KITTITAS COUNTY

MEMORANDUM

TO: All Staff
FROM: Justin Turnbull, County Surveyor 
DATE: December 22, 2020
SUBJECT: County Survey Review of BL-20-00025 Cle Elum Pines

ATTACHMENT A.
- NEW Configuration

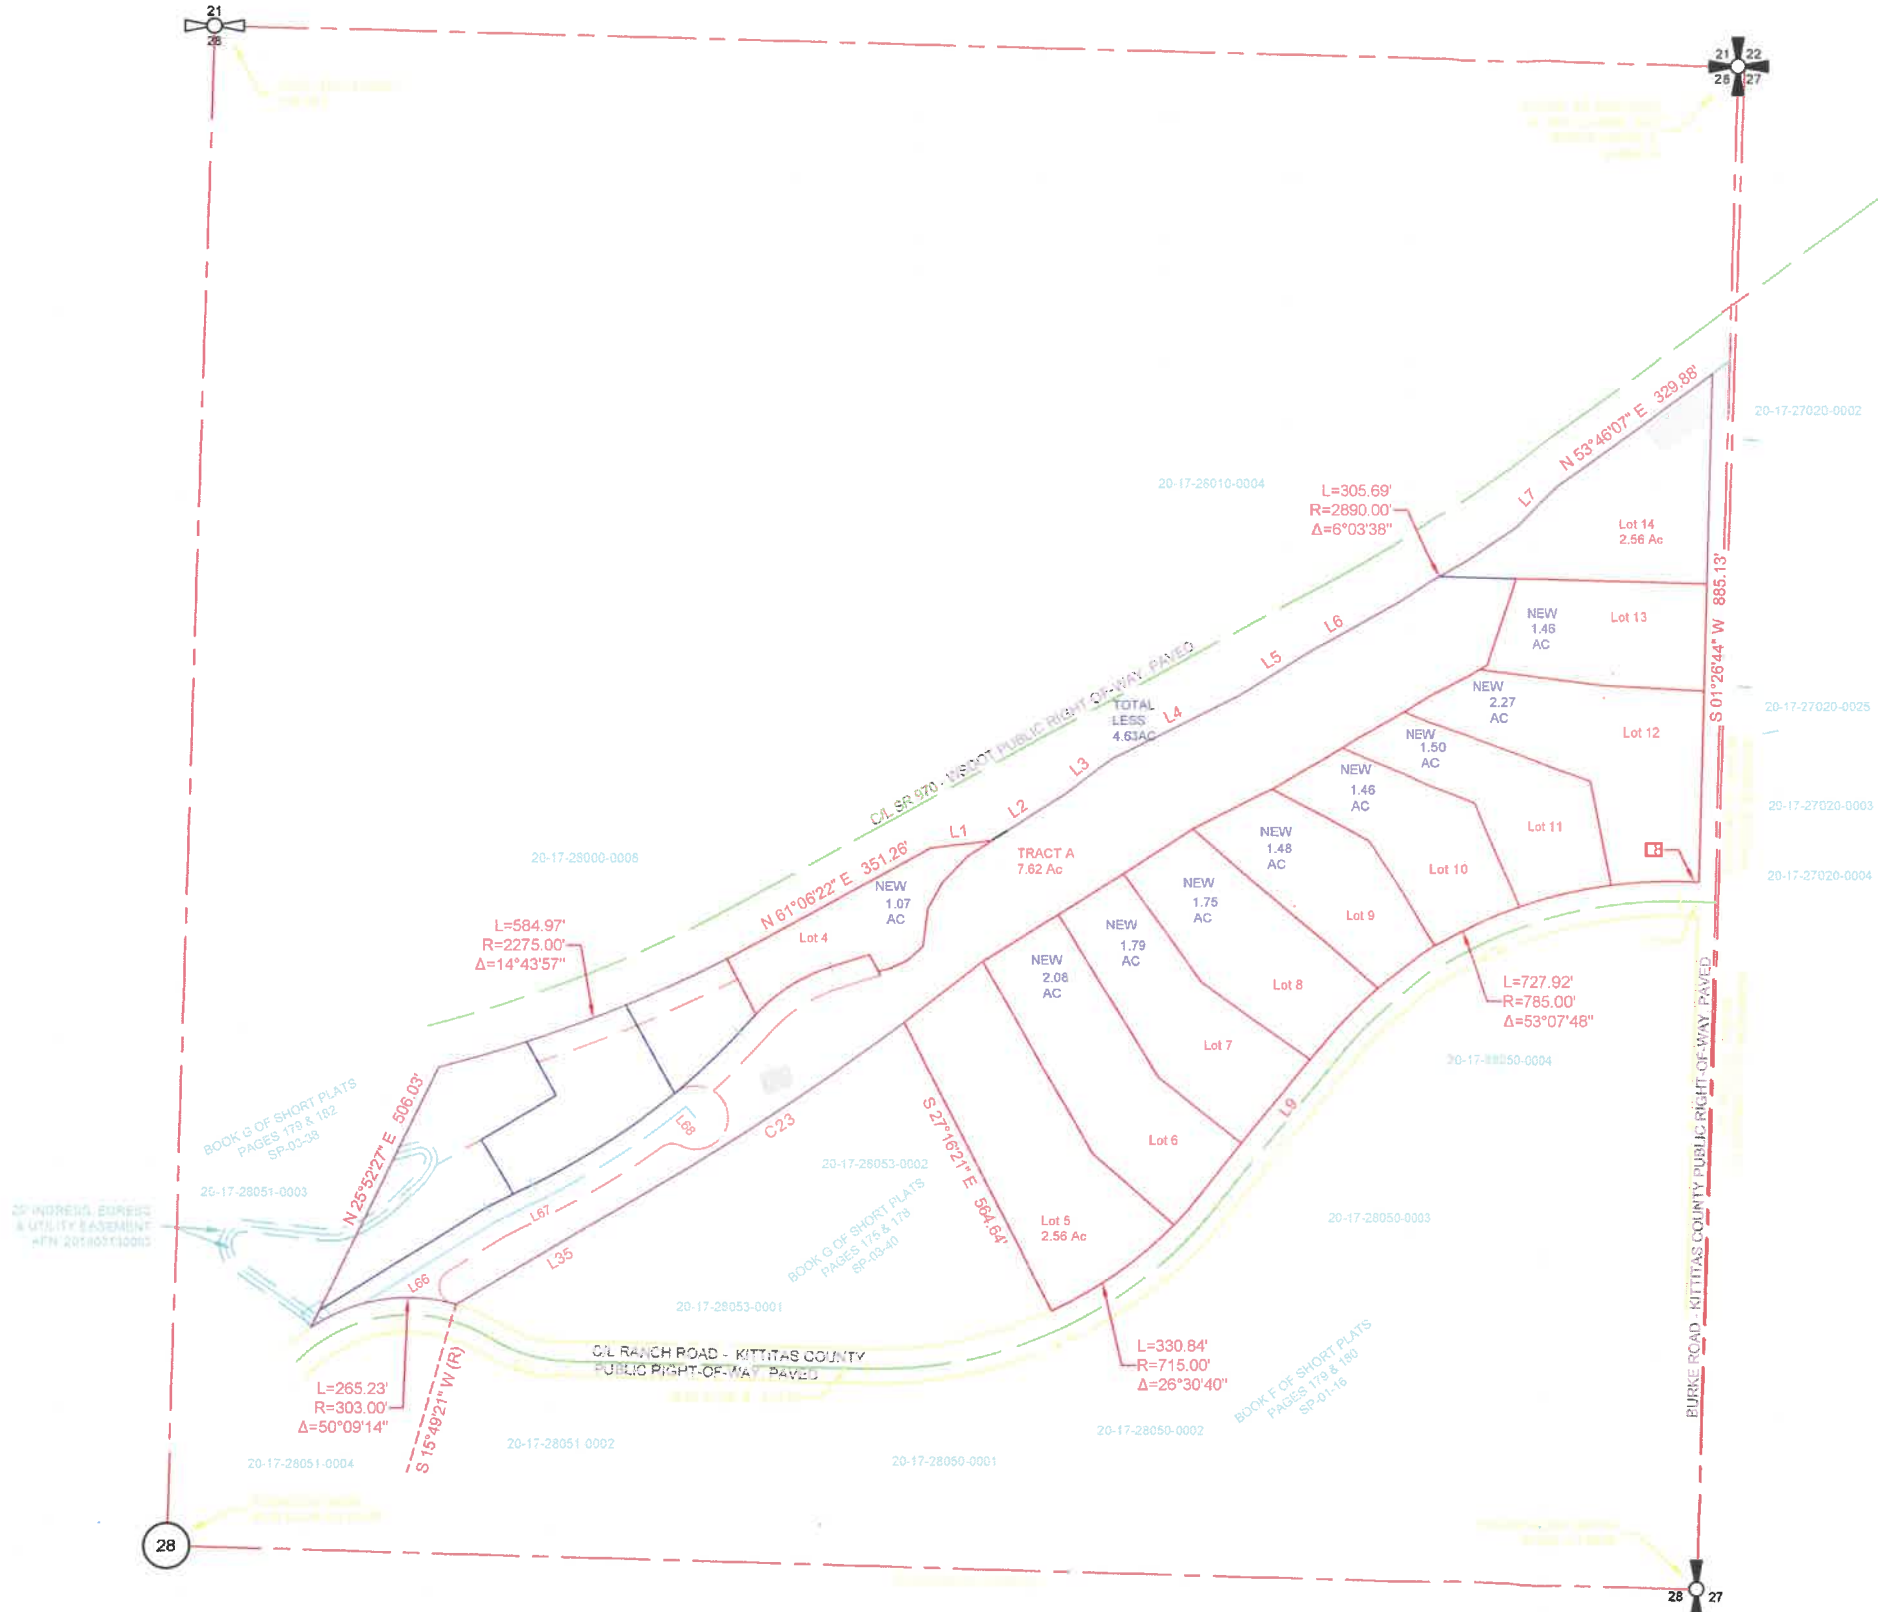
1. There is no actual ties linking the parcels to the section lines. (East end of line L9 to Sec cors)
2. There are some line labels on Lots 10A and 11A that are obscured by crossing linework.
3. The Note "lot line as a result of adjustment" on tract A-1 is obscured by crossing linework.
